Traffic Impact Study

# **Monument Hill**

El Paso County, Colorado

**The Garrett Companies**

FIGURE 1
MONUMENT HILL
EL PASO COUNTY, COLORADO
VICINITY MAP

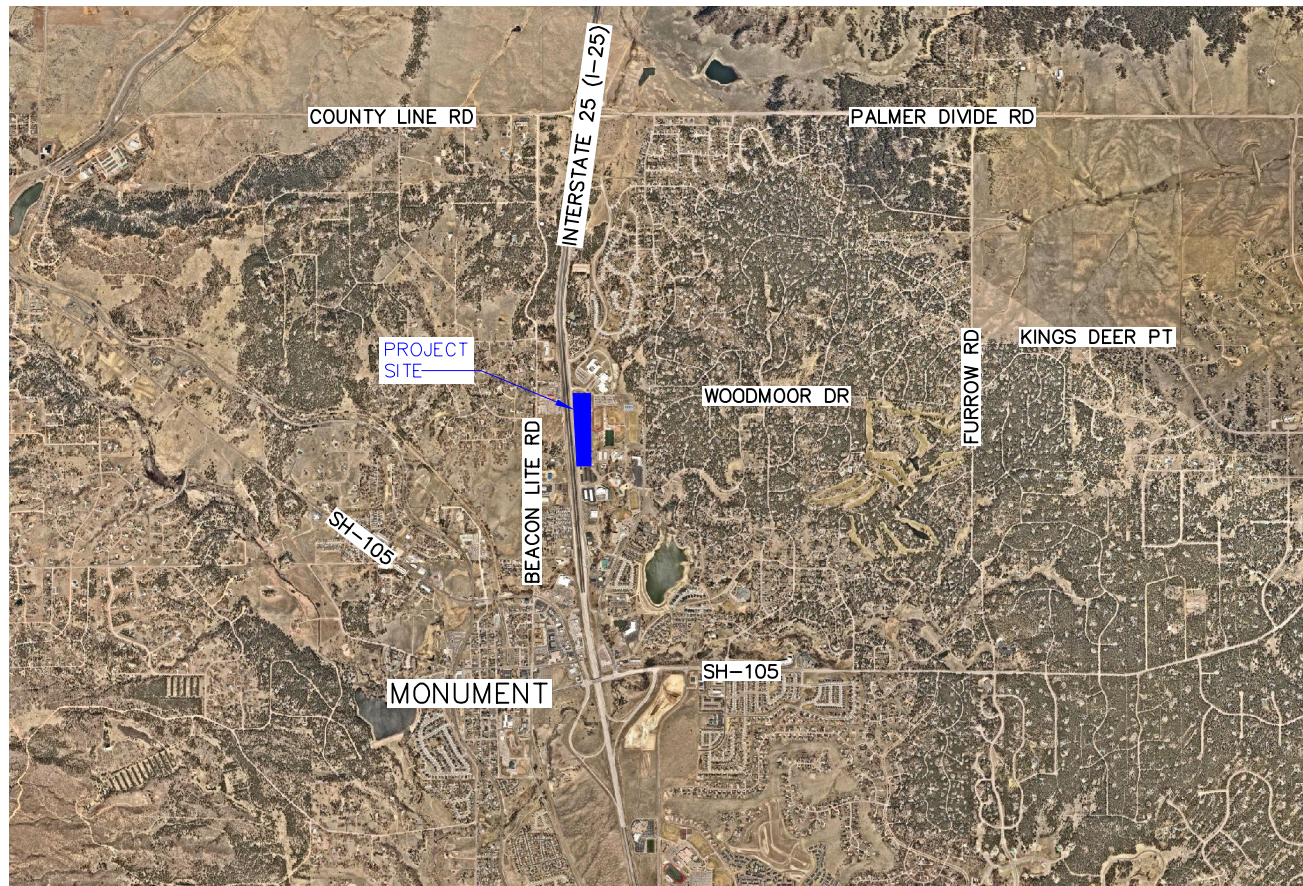
**Include Access at Base Camp Road**

FIGURE 3
MONUMENT HILL
EL PASO COUNTY, COLORADO
2022 EXISTING TRAFFIC VOLUMES

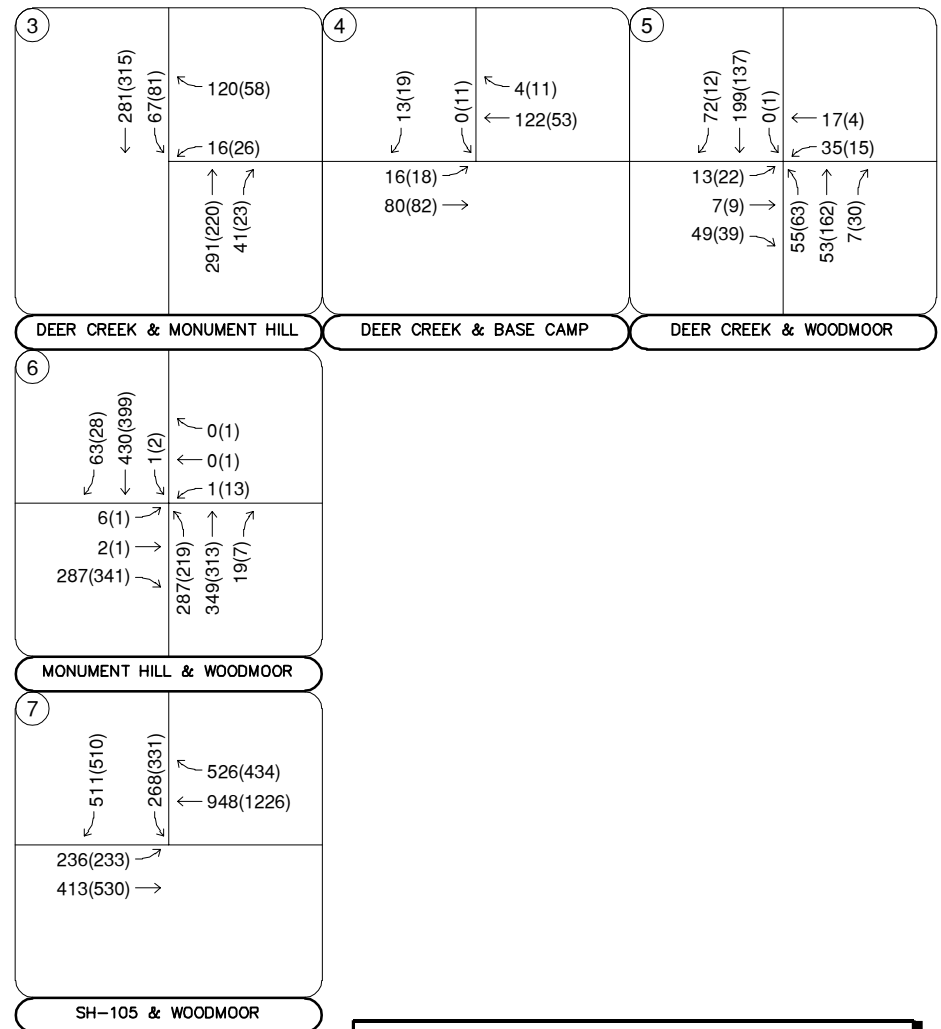
Highlighted counts do not  
match spreadsheet in  
appendix

Monument Hill Road & Woodmoor Drive (#6)

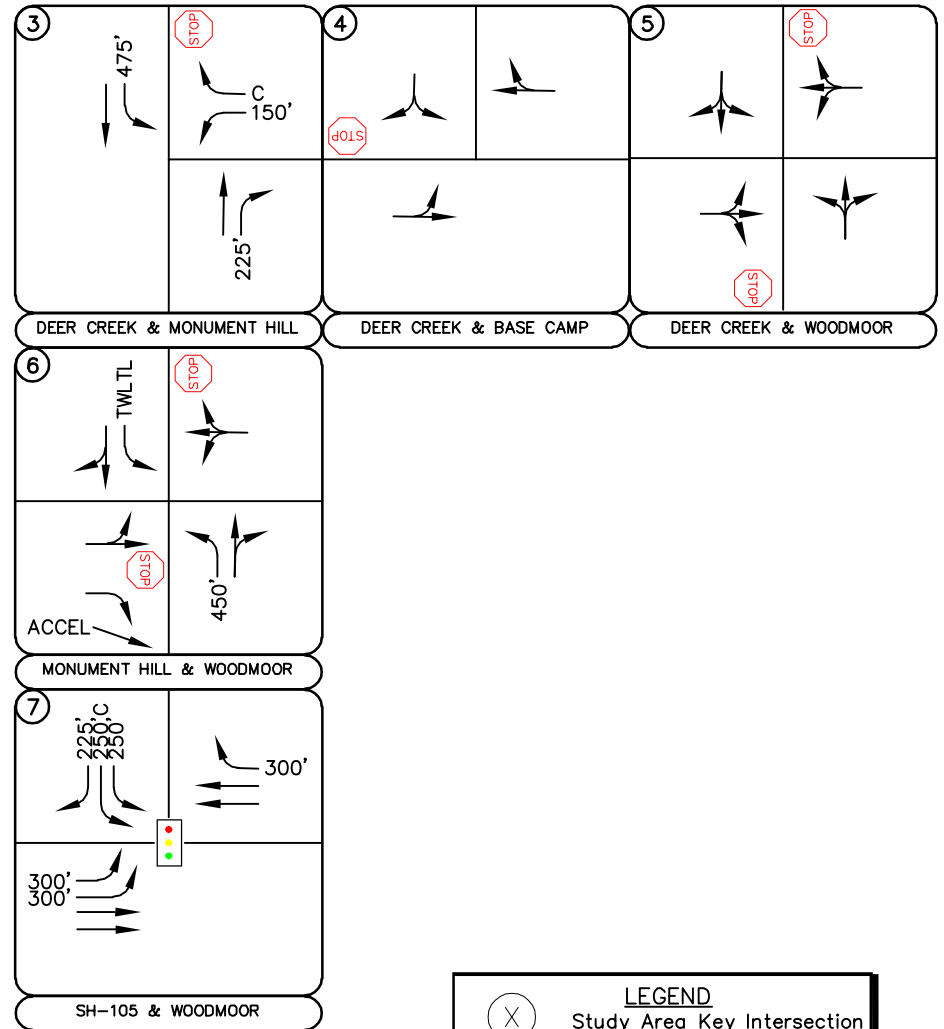
**Make note that east/west legs of Monument Hill are offset from each other**
